# Sandigo Solar Farm proposal

## Response to Submissions

May 2018

Figure 5: Vegetation Zones within the development site, scattered paddock trees and location of Plot surveys

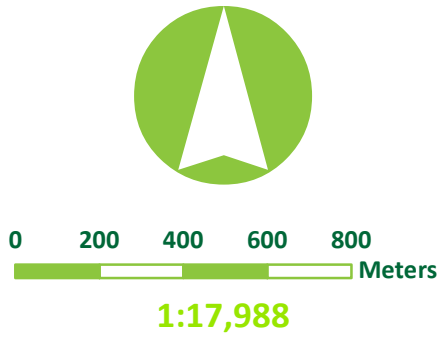
<p>In our letter providing OEH assessment requirements to DPE (EIS Appendix A, pages 19-27) we recommended the use of the Central Southern NSW vegetation mapping (VIS 3884). The BDAR used Riverina Regional Native Vegetation PCT Map Version v1.2 - VIS_ID 4469, which is a modified version of the recommended vegetation mapping.</p>	<p>We checked the differences between the two data-sets and differences were negligible. Therefore the contents of the BDAR have not significantly changed, however we have changed the reference to the preferred data source as requested.</p> <p>Reference to vegetation mapping source updated in section 3.2 and revised figures entered into Table 3.3.</p> <p>Map updated</p>
<p>The vegetation zones described in Section 2.1 do not match the zones mapped in Figure 5.</p>	<p>See response to comment relating to section 2.3.1 above.</p> <p>Map updated</p>
